Subject: FW: Response To Application Number Y/131/20/DOC at Land south of Ford Lane and East of North End Road, Yapton

Please upload onto Ocella the email below which is a further consultation response from the Local Highway Authority to discharge of condition application **Y/131/20/DOC**.

The consultation requiring comments in response to the PRoW and the cycleway across the site and the connections to Ford Lane should be under **Condition 8** of discharge of condition application **Y/131/20/DOC**.

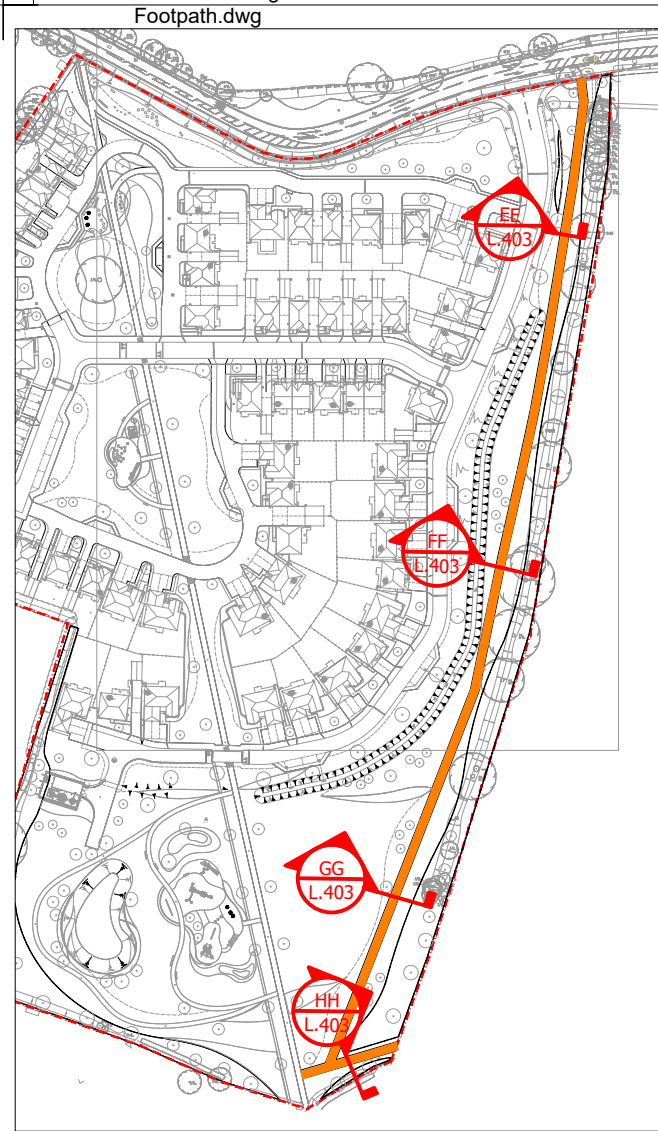
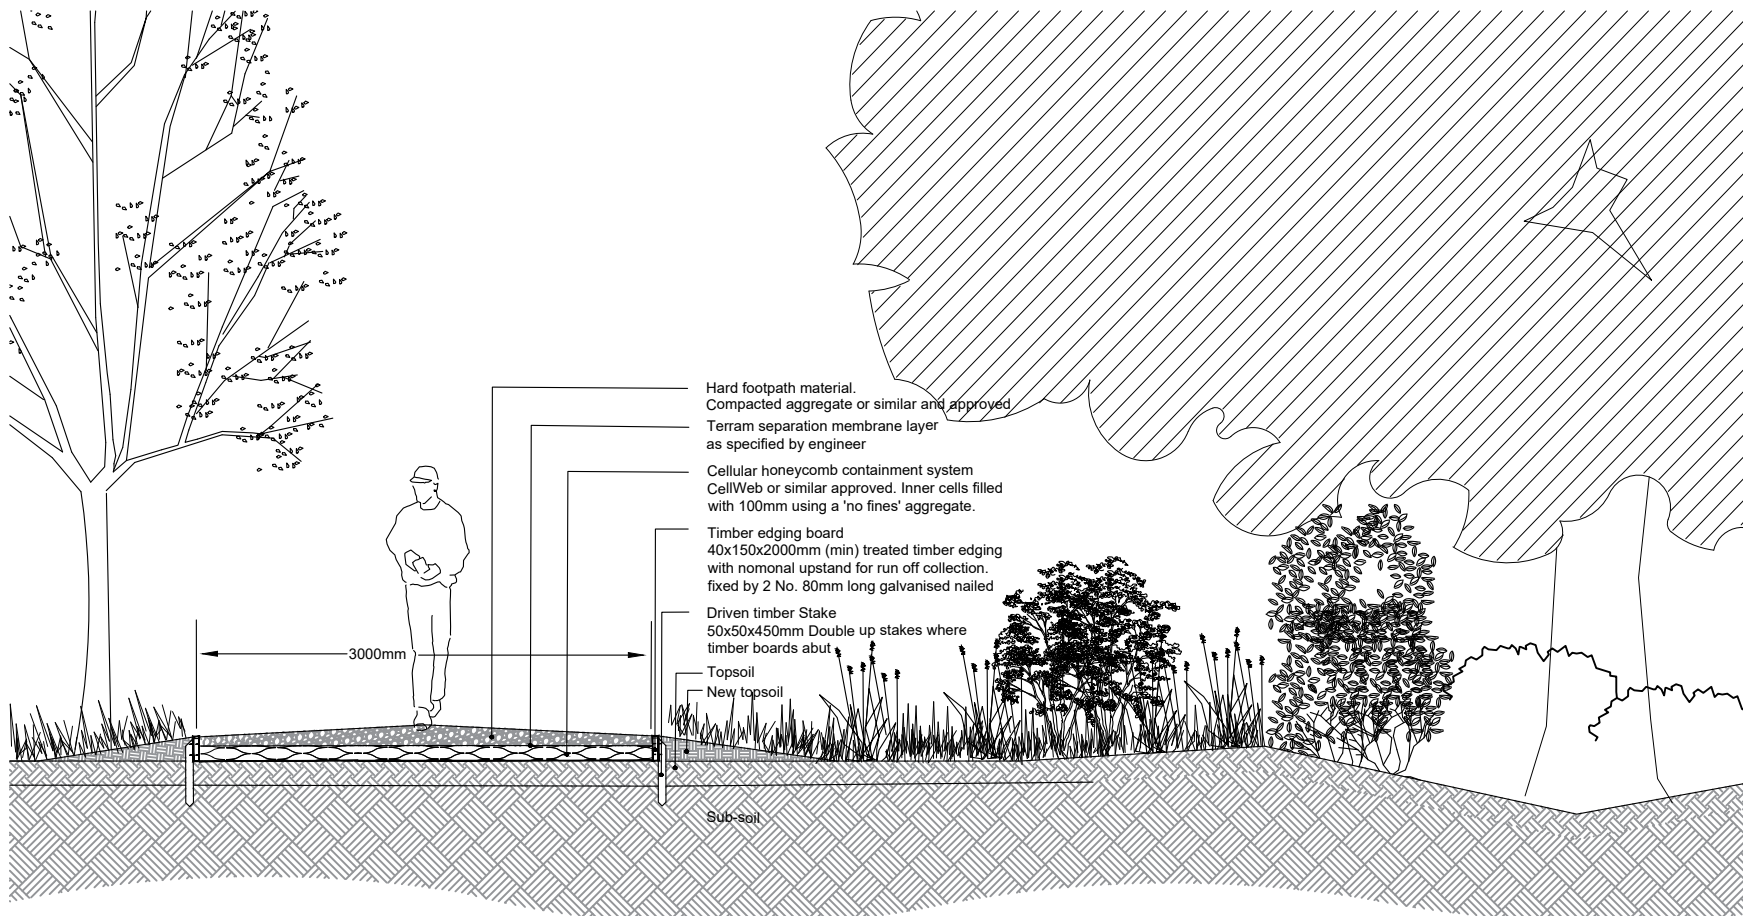
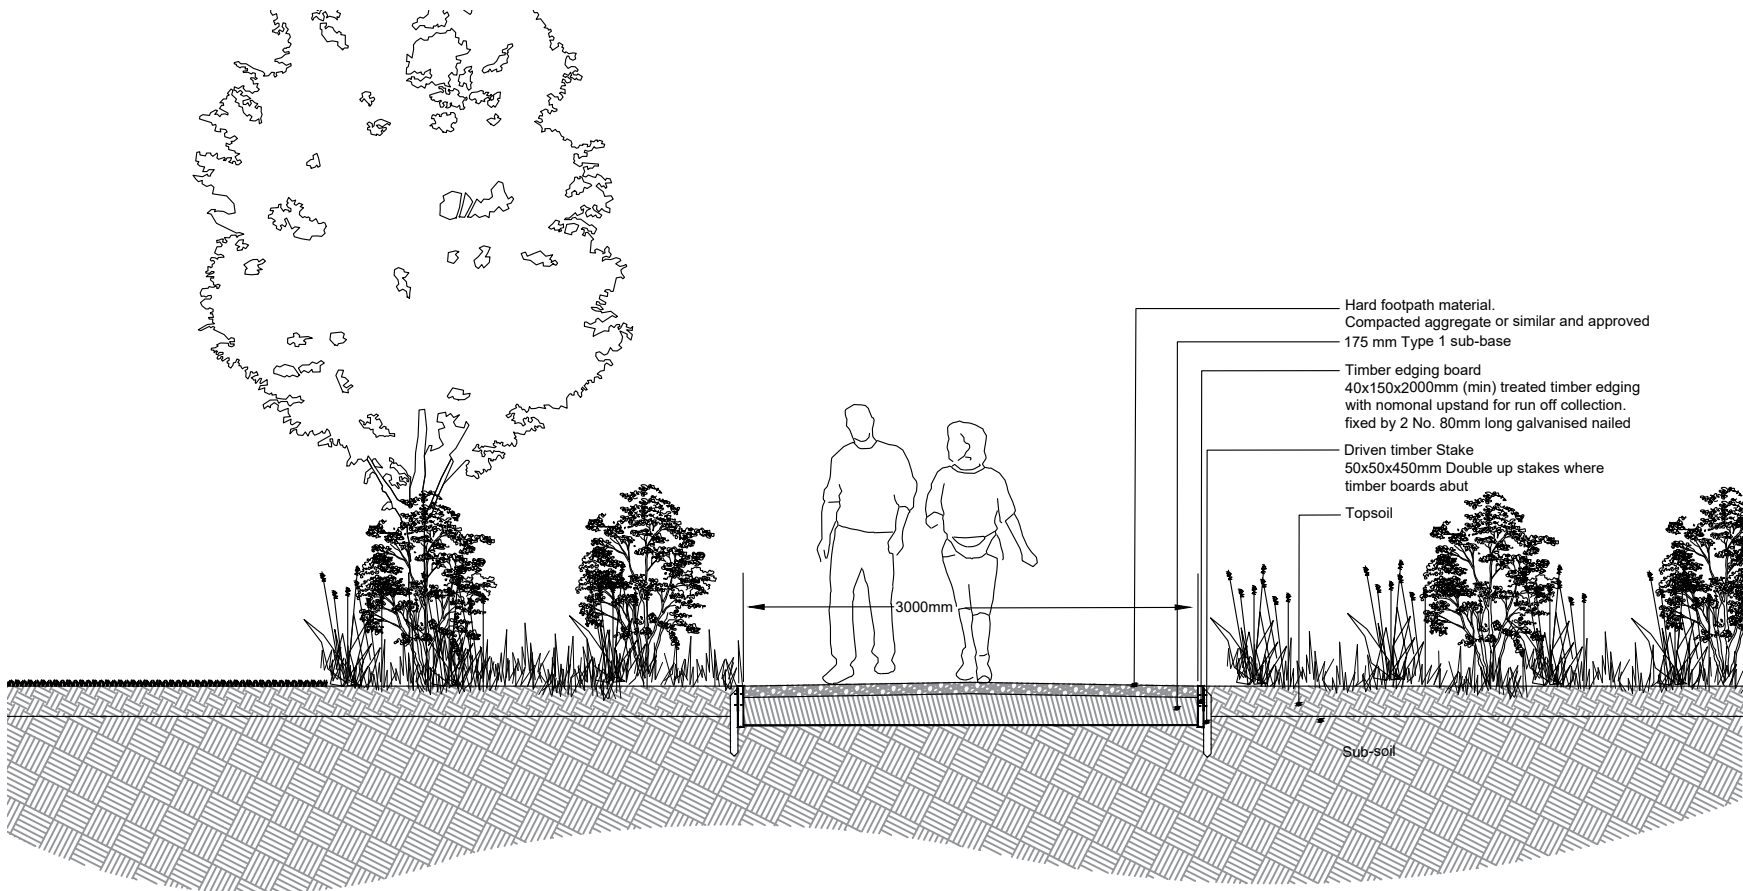
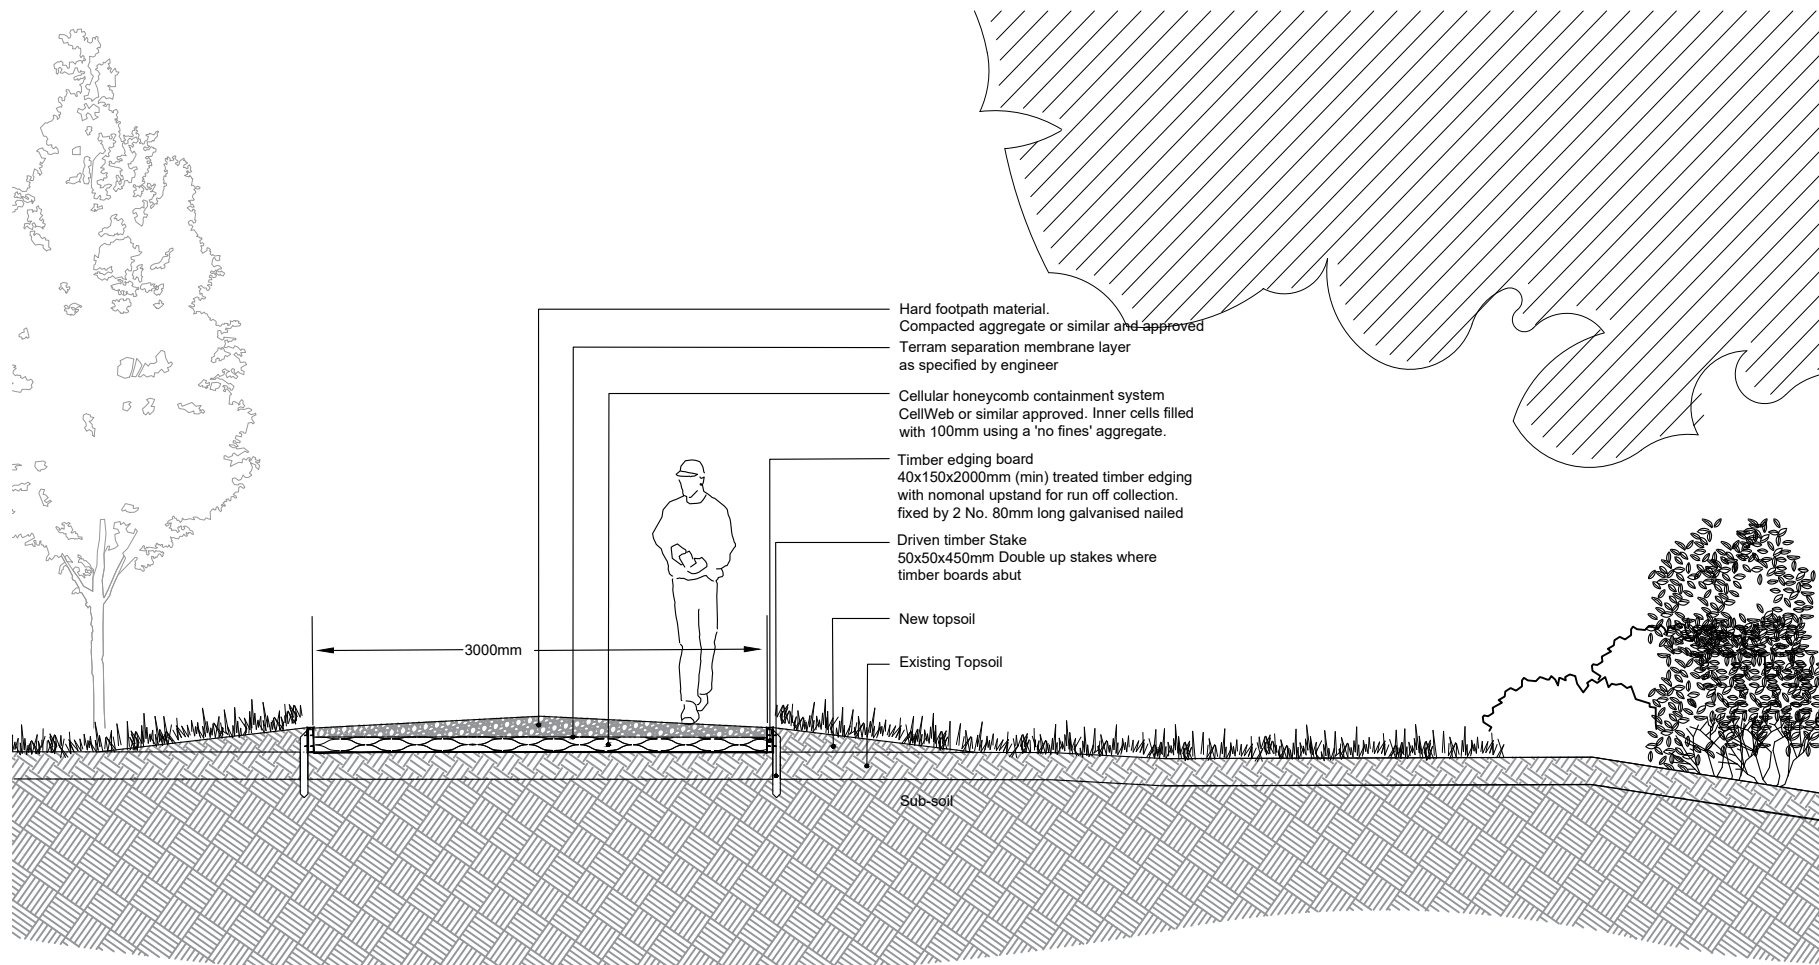
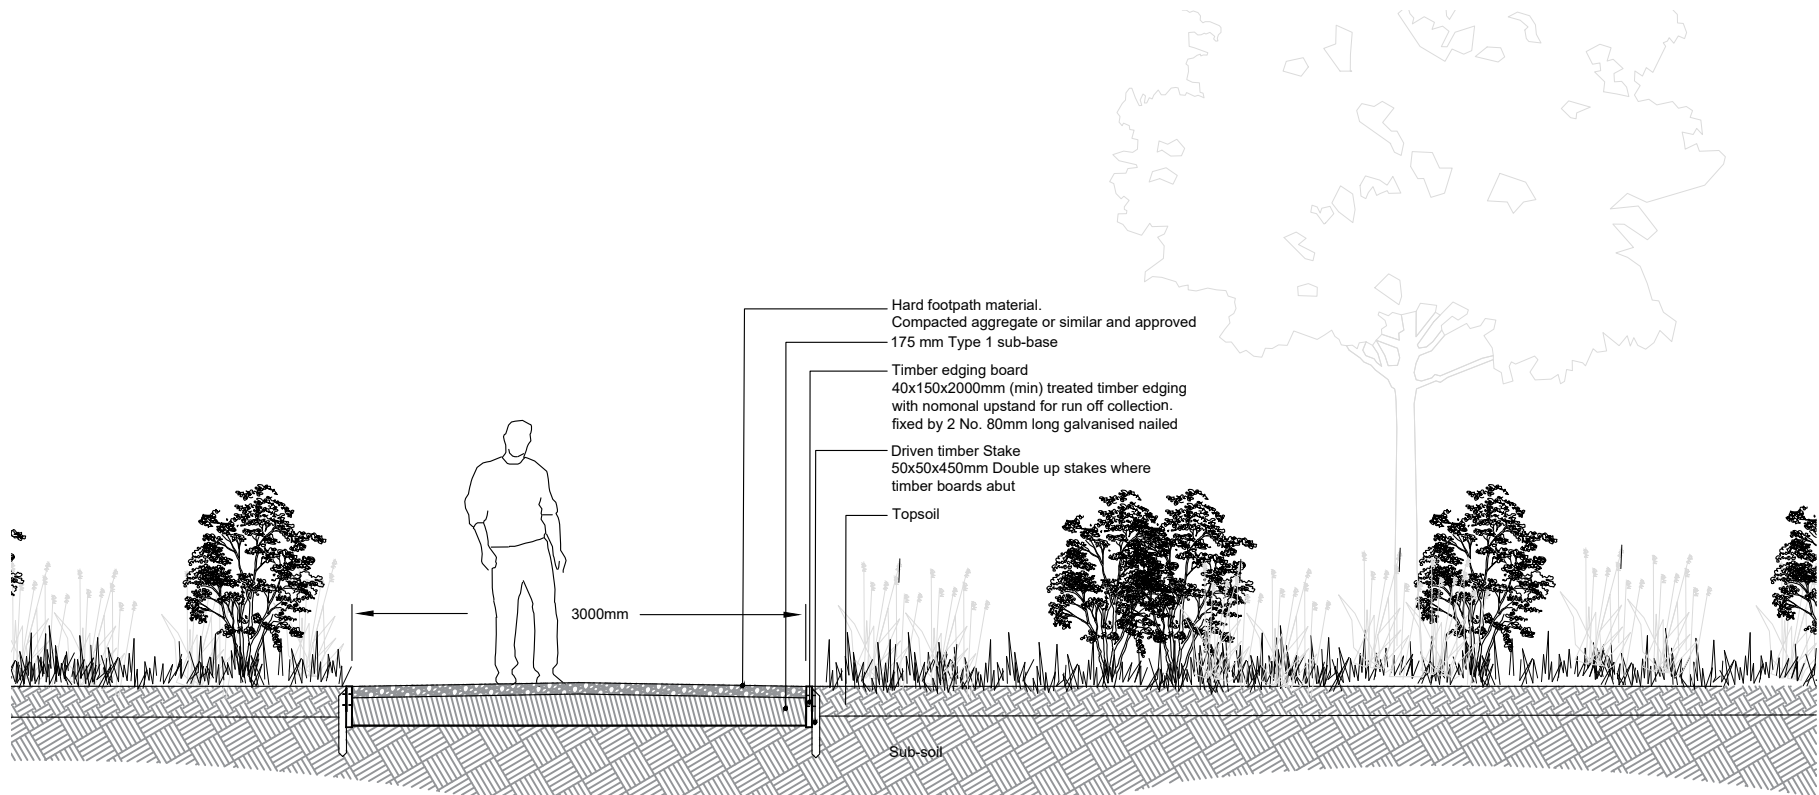
It would be advisable if the existing Footpath 358, which runs along the Eastern side of the site be referred to as 'Proposed Bridleway' as this is our eventual aim and this will avoid confusion as we proceed. Likewise existing Footpath 357 across the site should be denoted as 'Proposed Cycleway' for the same reason.

Tim rightly raises the point regarding the short section of Footpath 359 which exits the site in the S/E corner. Initially I had discussion with Craige regarding a suitable surface here to ensure it would cope with increased footfall from the site. Given the potential of further development to the East it is highly likely we would seek to further improve local access as part of any proposal on the neighbouring site.

In preparedness of seeking FP359 as a further Bridleway link heading East it would seem logical to achieve this short section to the same standard as FP358 as part of the agreement. Given the relative short distance involved this could be easily achieved in tandem with the surfacing works the developer will be undertaking on FP358 when the time comes.

Movement Plan

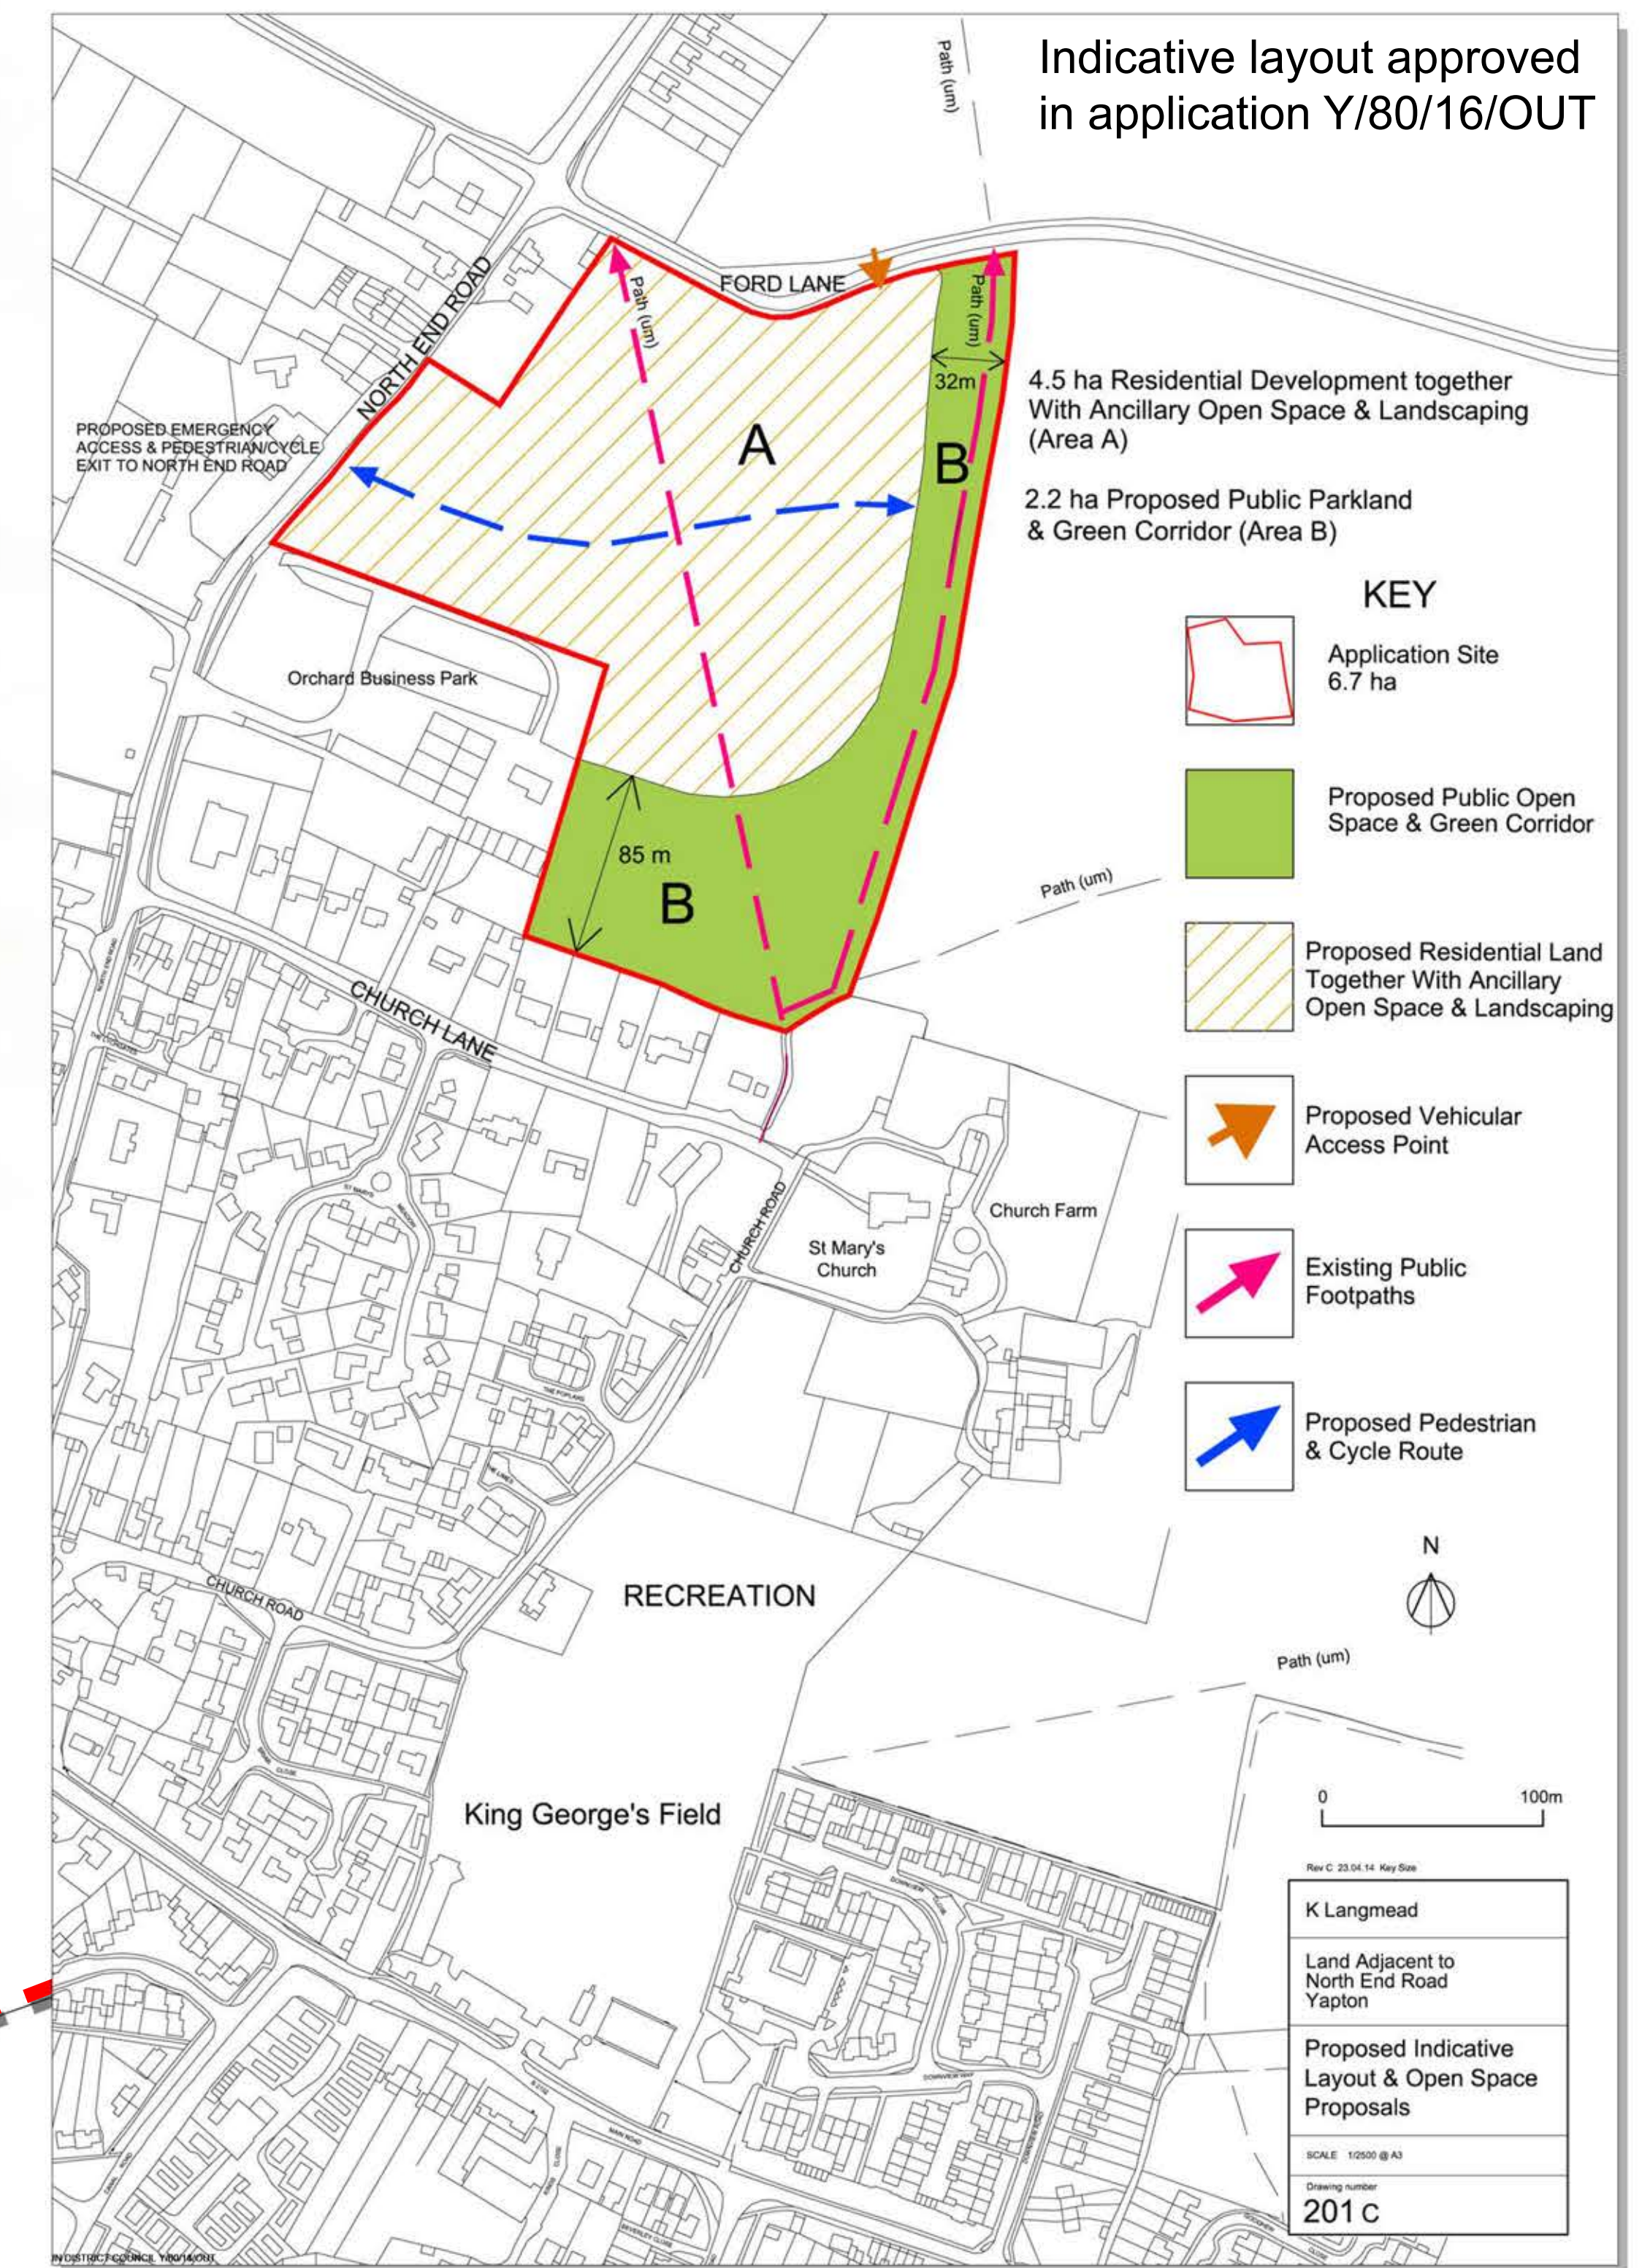
My understanding is that the applicant in their 'movement/accessibility plan' has accepted the principle of Public Footpath 357 becoming a shared foot and cycle way whereas Public Footpath 358 will be upgraded to Bridleway status. As such we would need to see the details of how they join and interact at the points they join Ford Lane and how they terminate south of the site. This will require plans from the applicant and either a further Stage 1 Road Safety Audit or Supplementary Road Safety Audit (if the latter is permitted under GG119) to ensure that any changes required as a consequence of the change of status of the paths has been properly considered. Another PROW - Public Footpath 359 - shouldn't need altering at the present time other than the developer confirming that space either side would not be encroached upon as part of this development. The reason for this is that if development comes forward to the east at some time in the future there would then be scope to upgrade this path too. Including the path, an overall width of 5.0m would be sufficient taking the path as centreline to this.
